**CITY OF ALBUQUERQUE  
ADMINISTRATIVE APPROVAL (AA)-  
SITE DEVELOPMENT PLAN AMENDMENT TRACKING SHEET**

APPLICATION #:	SI-2019-00362	PROJECT #:	PR-2019-003013
PROJECT NAME:	Taylor Ranch Library		
ADDRESS:	5700 Bogart St NW		
APPLICANT or AGENT:	Deen Smith		
PHONE #:	768-5170	EMAIL:	dpsmith@cabq.gov
ZONE ATLAS PAGE:	E-10		
ADMINISTRATIVE APPROVAL (AA) for:	<input type="checkbox"/> EPC CASE <input type="checkbox"/> DRB CASE

C1
AS501
PARKING SIGNS
SCALE: 3/4" = 1'-0"

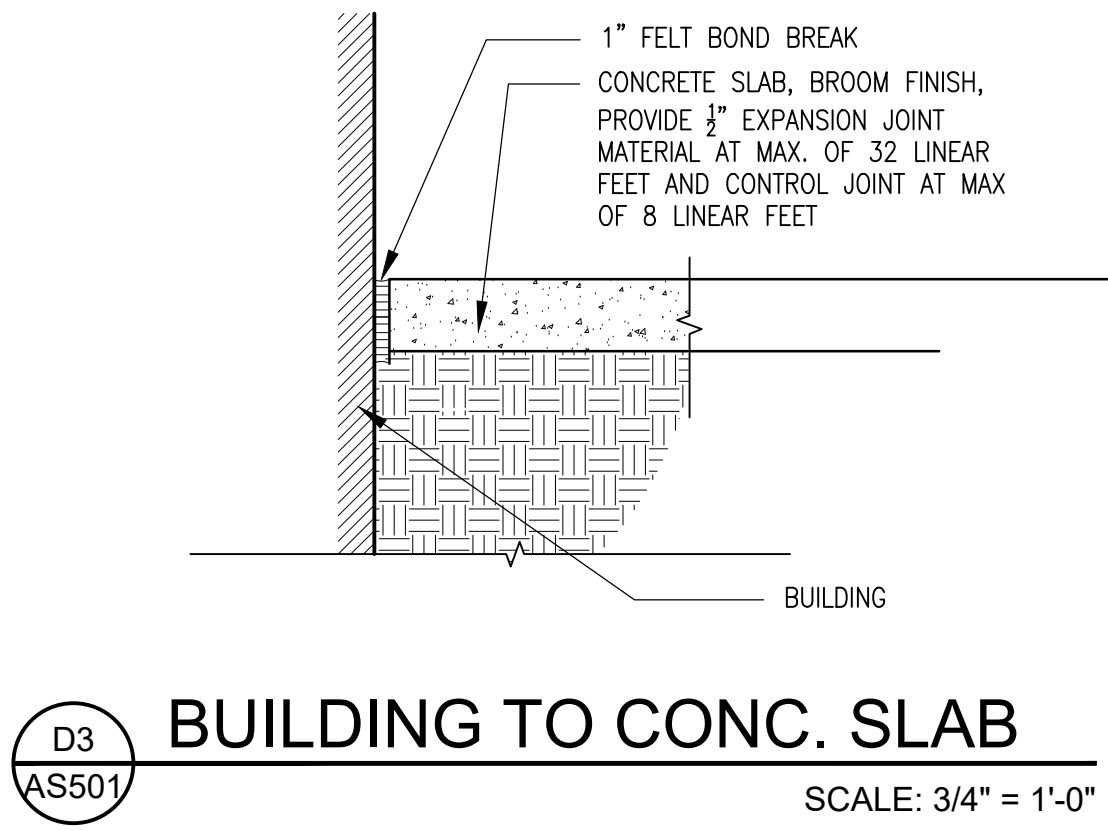
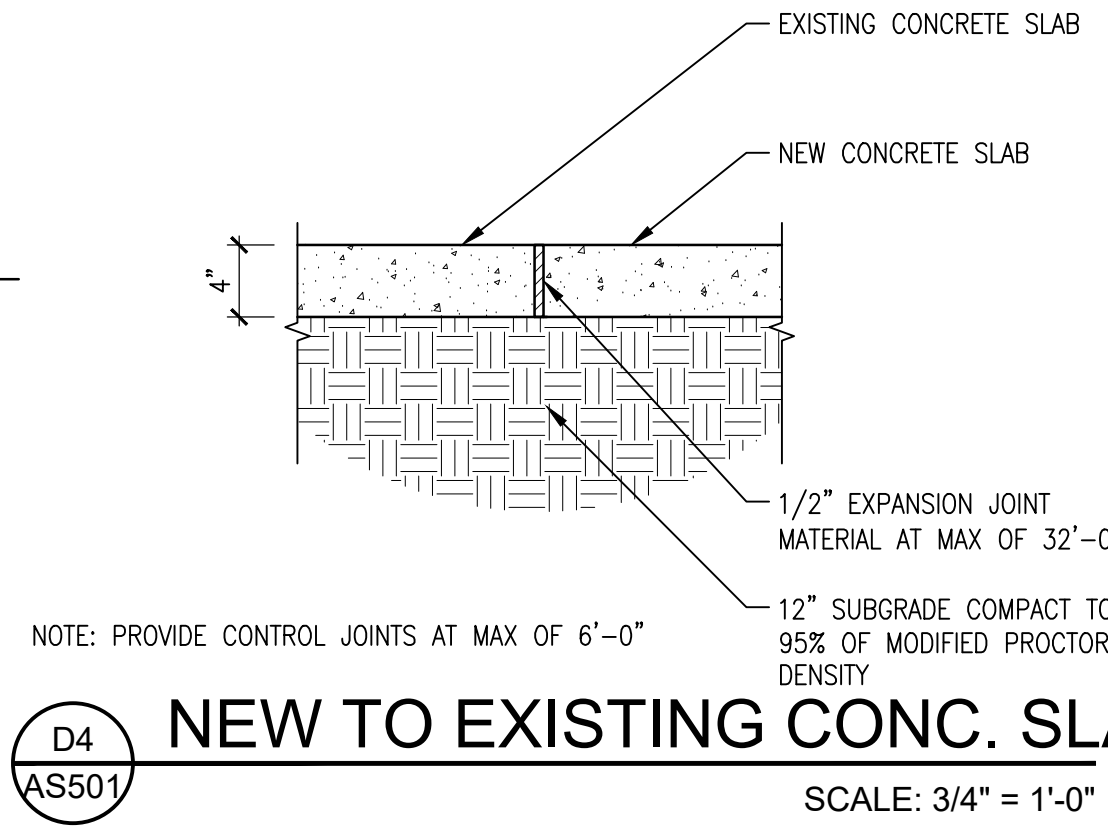
CURRENT PLANNING	DATE RECEIVED:
APPLICATION COMPLETE:	DATE:
APPLICATION INCOMPLETE:	DATE:
ROUTING NEEDED TO: <input type="checkbox"/> NONE	<input checked="" type="checkbox"/> TRANSPORTATION <input checked="" type="checkbox"/> HYDROLOGY <input type="checkbox"/> ABCWUA
DATE COMMENTS ARE DUE FROM AGENCIES:	
COMMENTS: - Hydrology - Hydrology will need an updated Grading and Drainage Plan. Meet Fire Hydrant requirements. (Shahab)	
- ABCWUA - (David Gutierrez) - Approver fire hydrant changes	
- Transportation - (Jeanne) - Dimension new motorcycle spaces, call out motorcycle sign and provide sign detail.
